CITY OF ALBUQUERQUE

PLANNING DEPARTMENT – Development Review Services

January 8, 2016

RE: Izzat Subdivision (File: C20D069)
Grading and Drainage Plan, Engineer's Date 2-11-2014
Certification Date: 12-20-15

1 GRADING PLAN

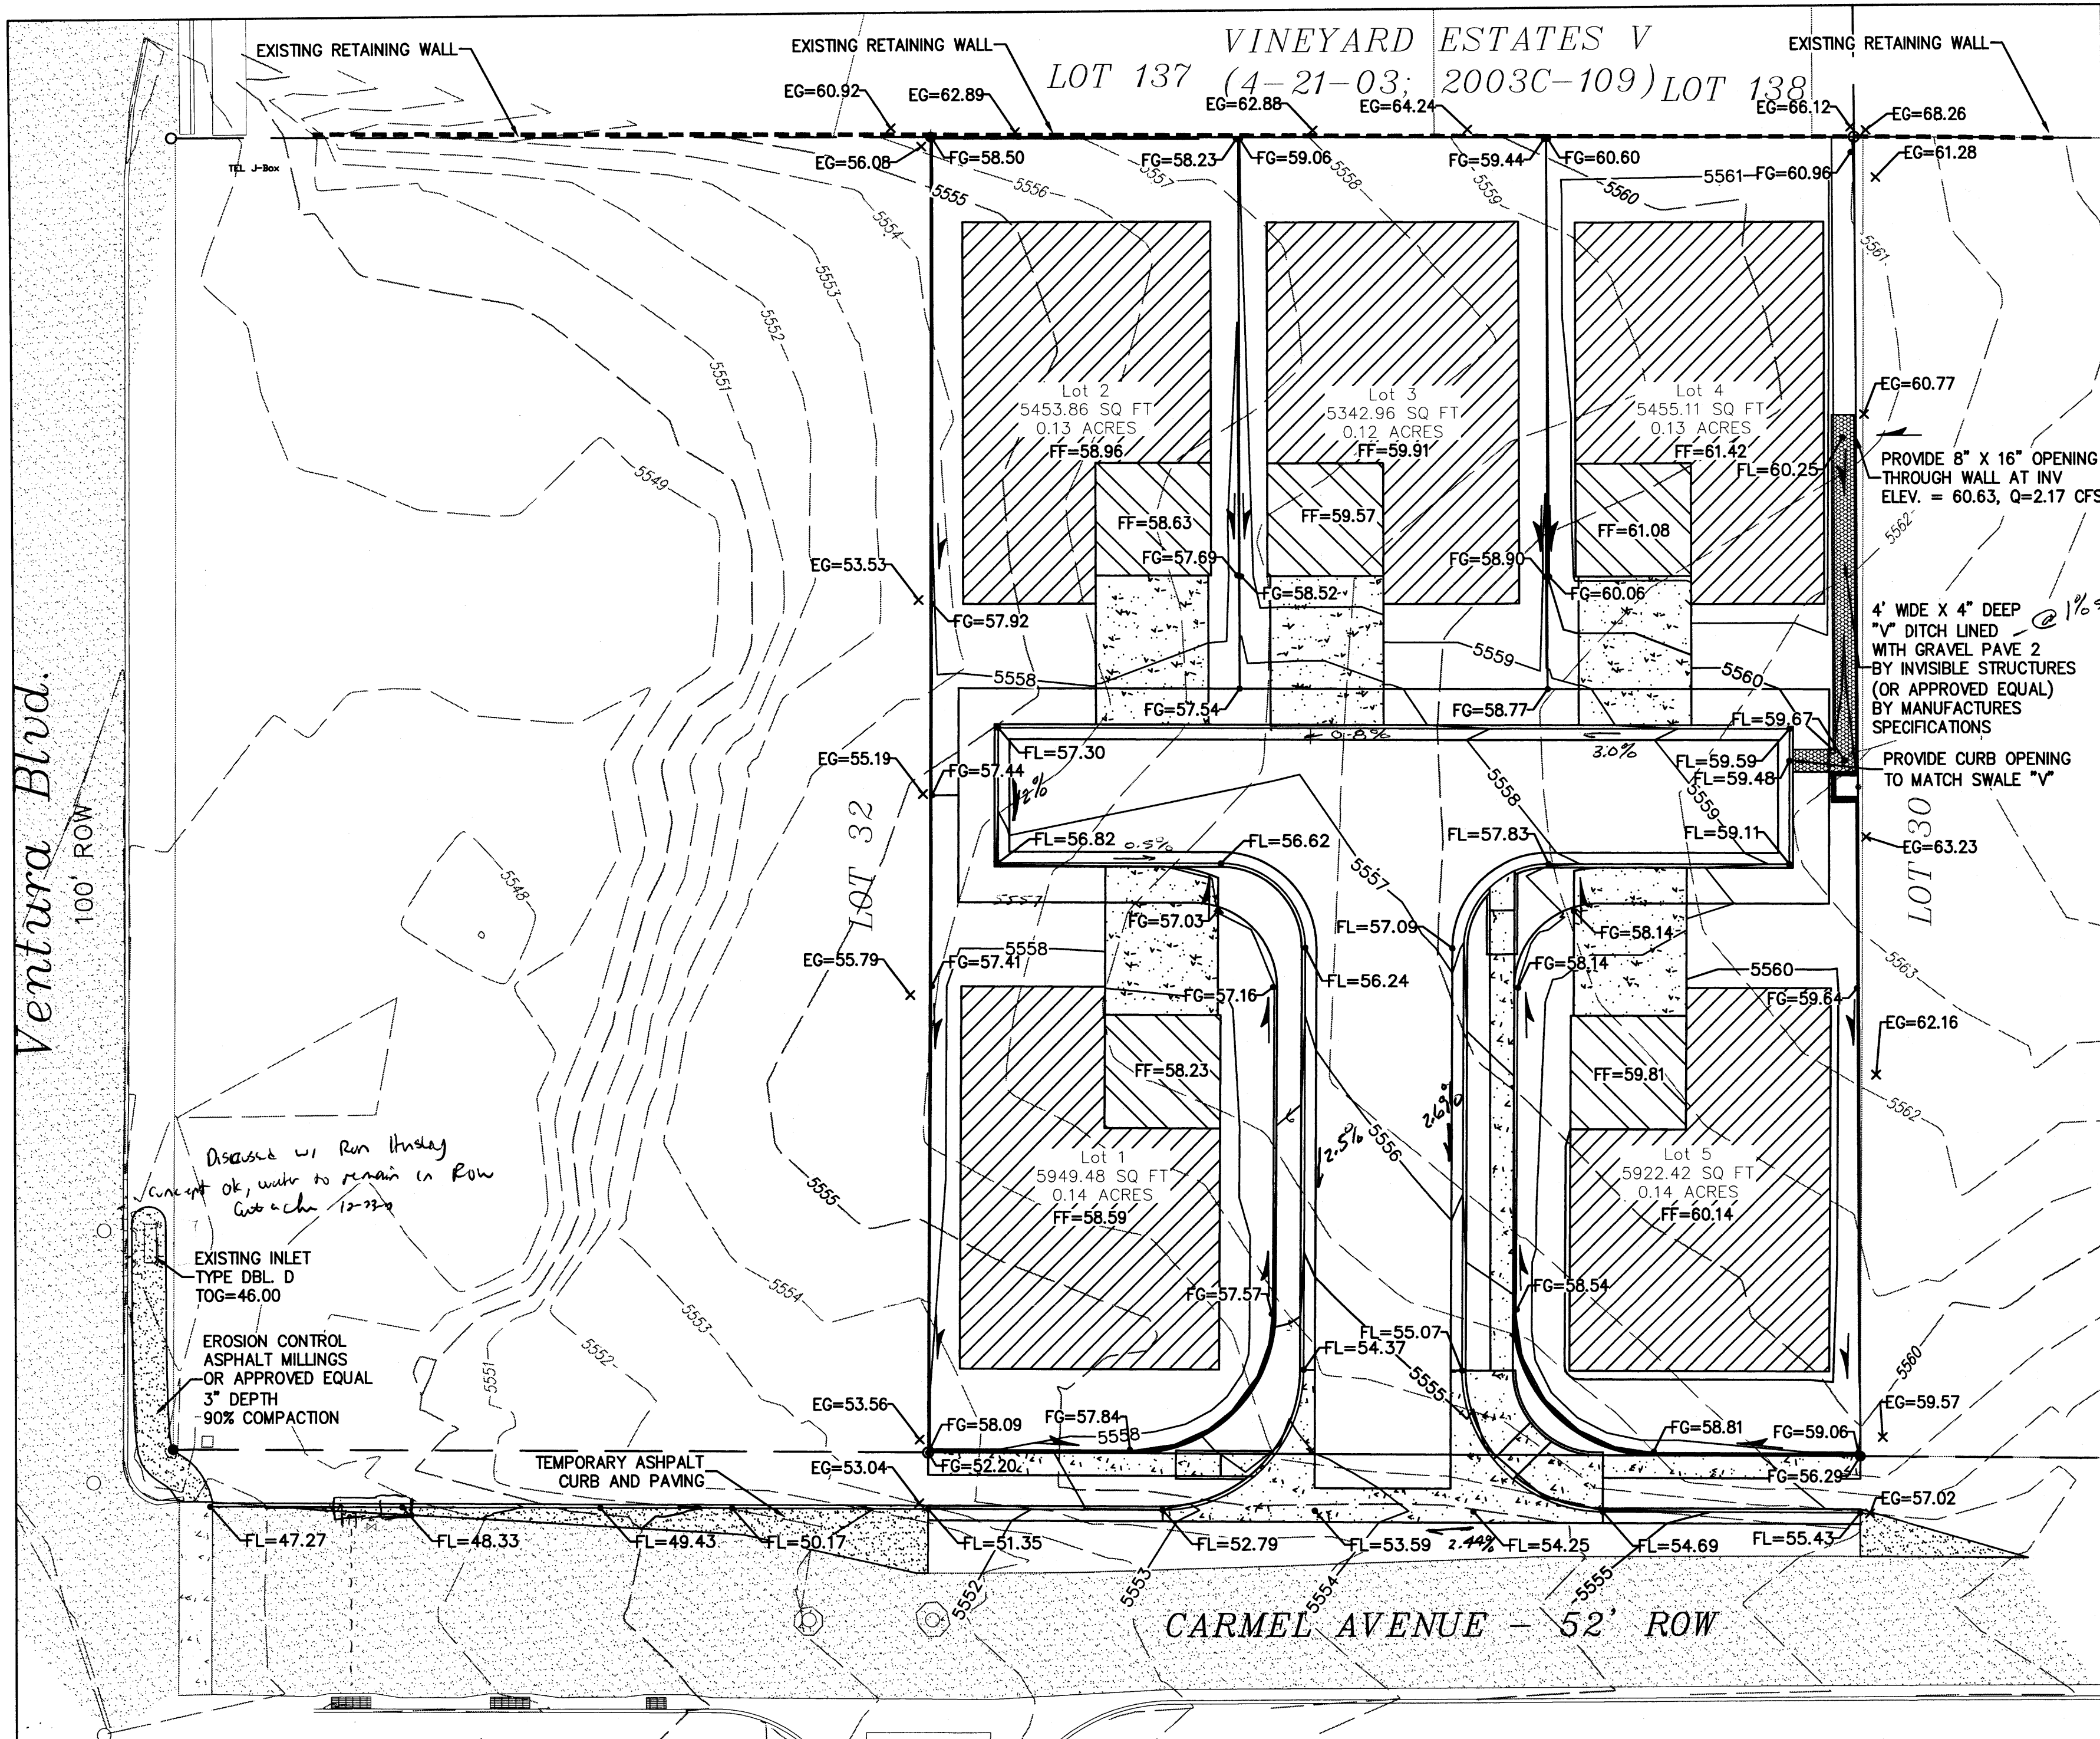
Based upon your Engineer's Certification submitted on 12-22-2015, the above referenced plan is adequate and satisfies the Grading and Drainage Certification for Release of Financial Guaranty, with the exception of the wall openings and swale along the NE property line. C.O. for Lot 4 will be contingent on a future submittal certifying that the swale and wall openings along the NE property line are built.
